CITY OF ALBUQUERQUE

June 22, 2017

RE: **Lot 31 Block 6 Unit 18, S.A.D. 228**
6543 Pato Rd. NW
Grading and Drainage Plan
Engineers Stamp Date 6-19-17 (D10D003M31)
Engineers RevisedStamp Date 6-20-17

Topographic Survey
For Grading and Drainage
Address 6543 Pato Road NW Albuquerque, NM
Lot 31 Block 6, Volcano Cliffs, Unit 18
Albuquerque, Bernalillo County, NM
Book D4 Page 106, 01/19/1971
June 2017

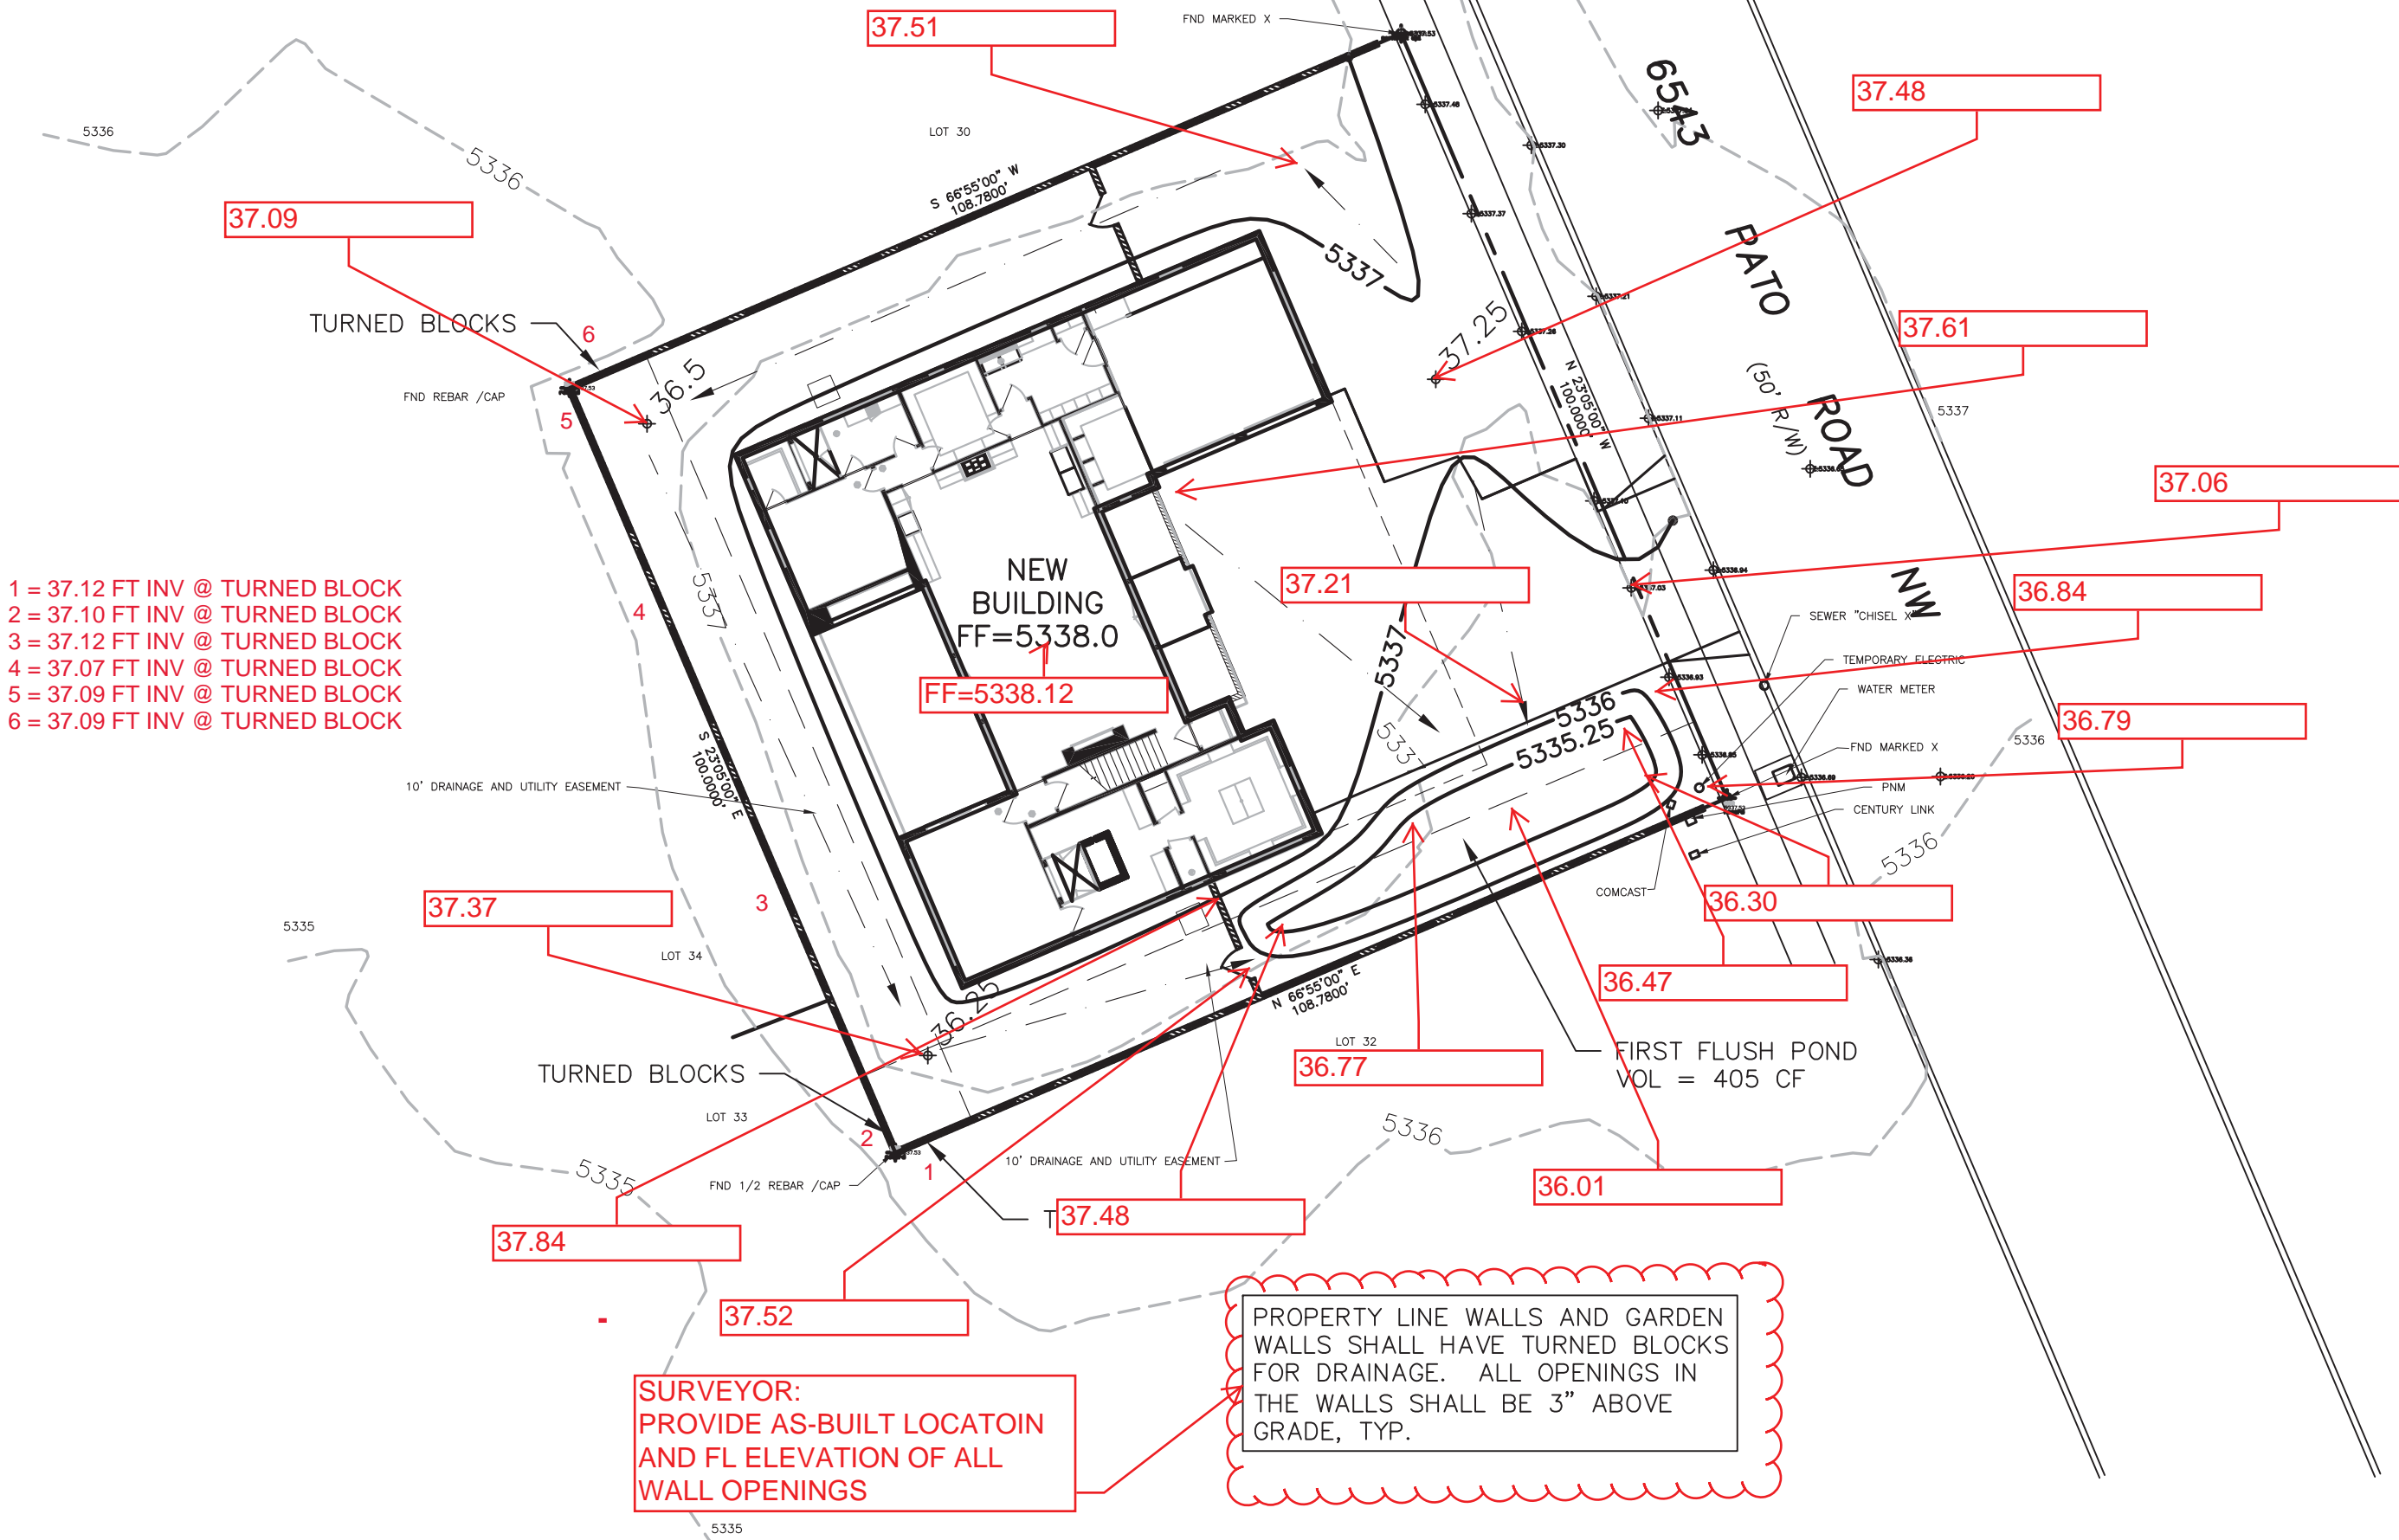
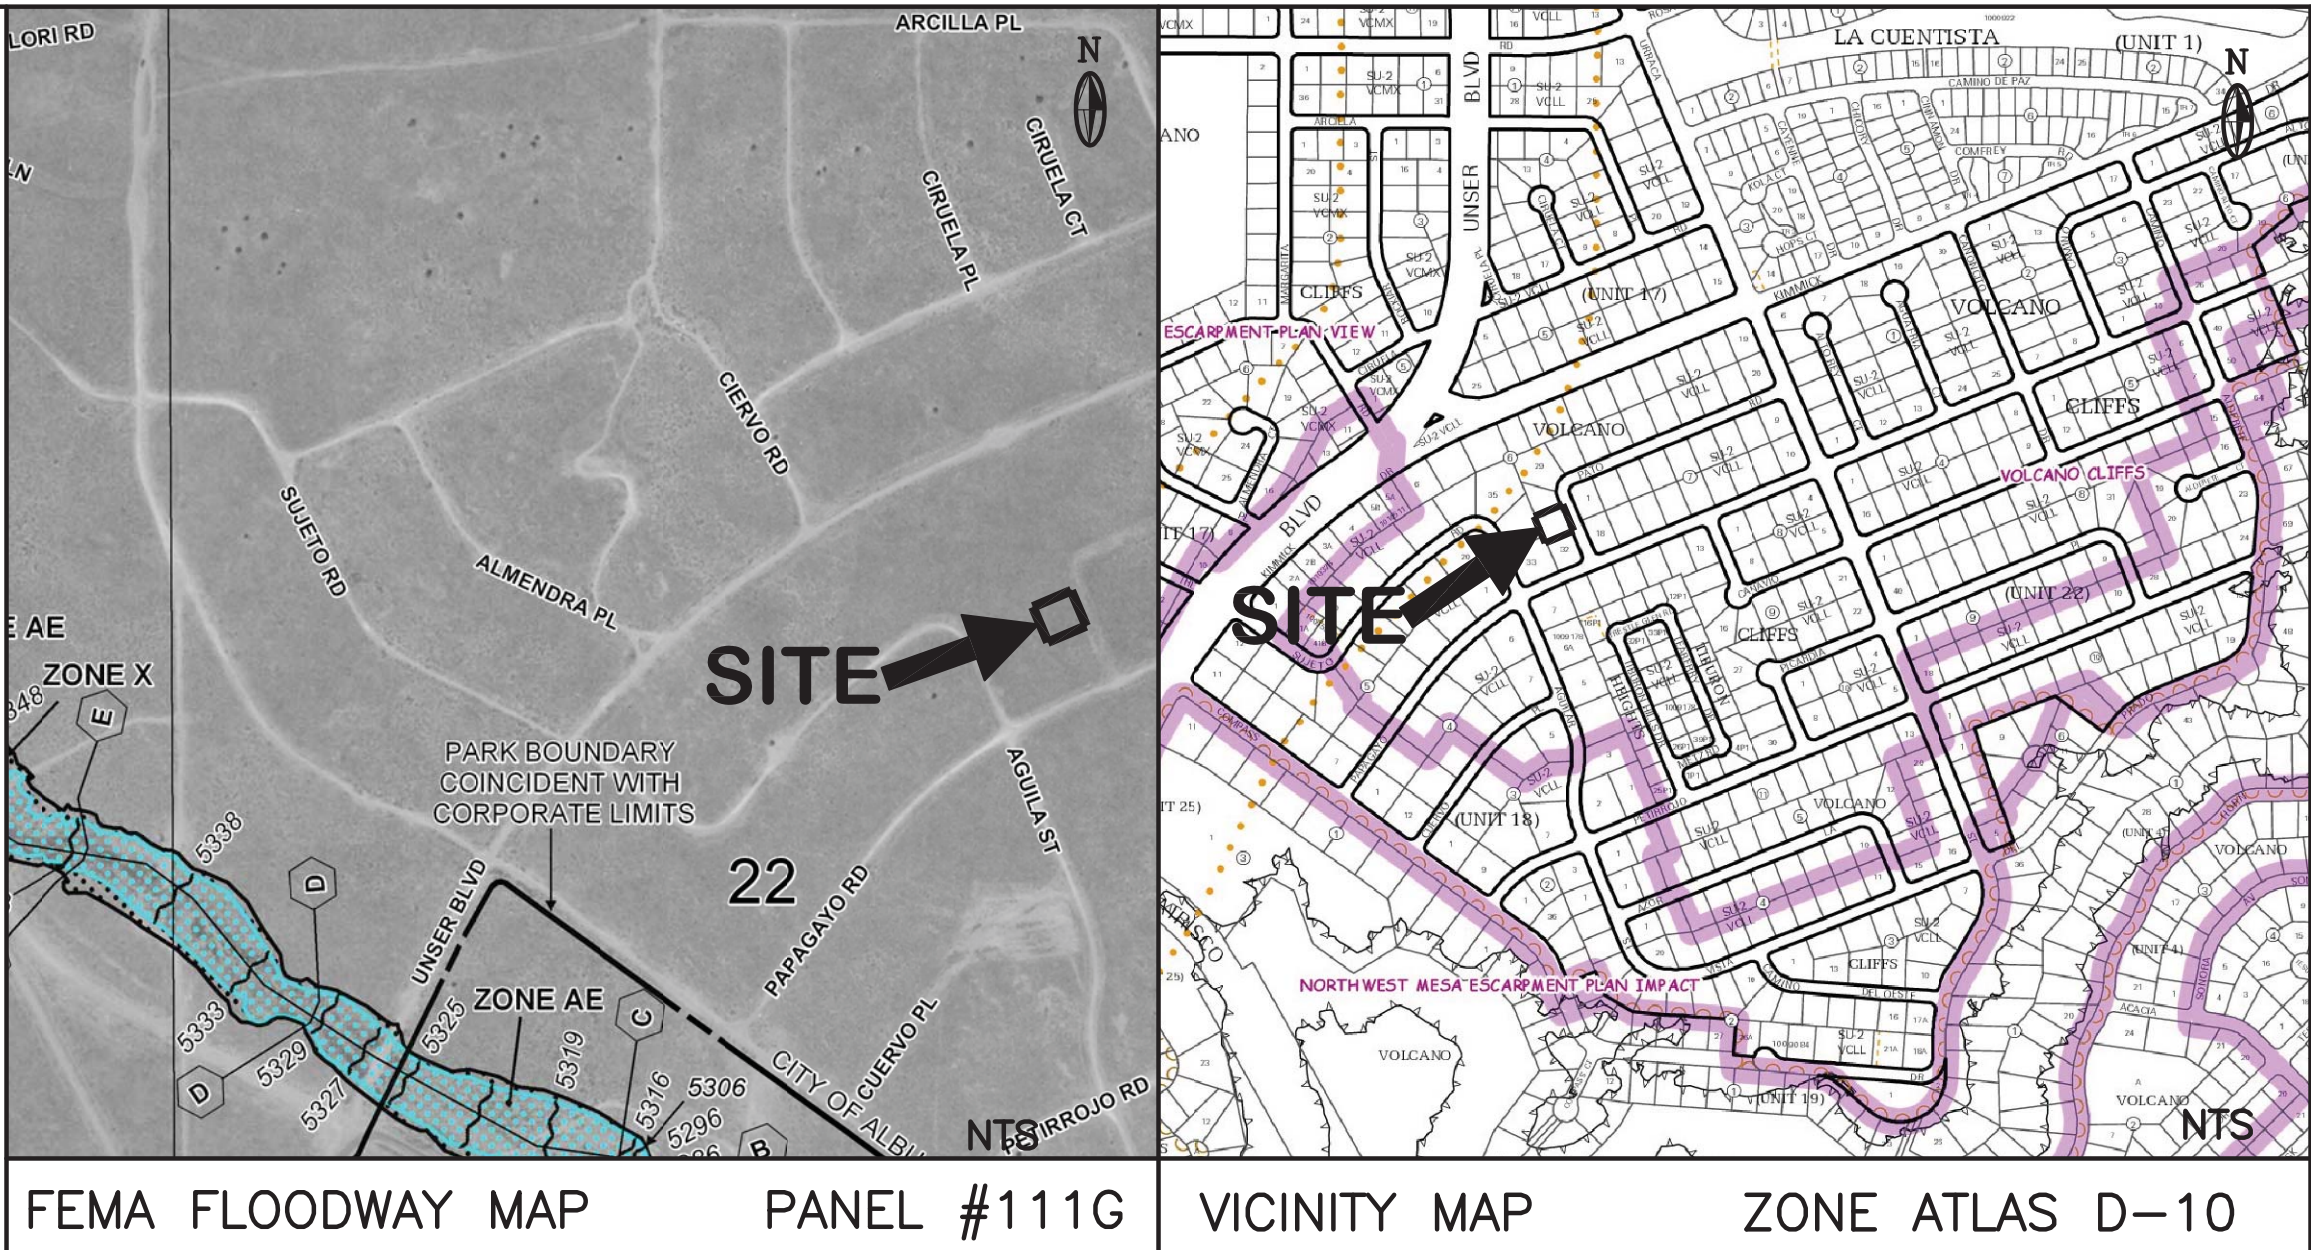
- Provide the openings in the PUE and remove the words, weep holes.
See attached exhibition.
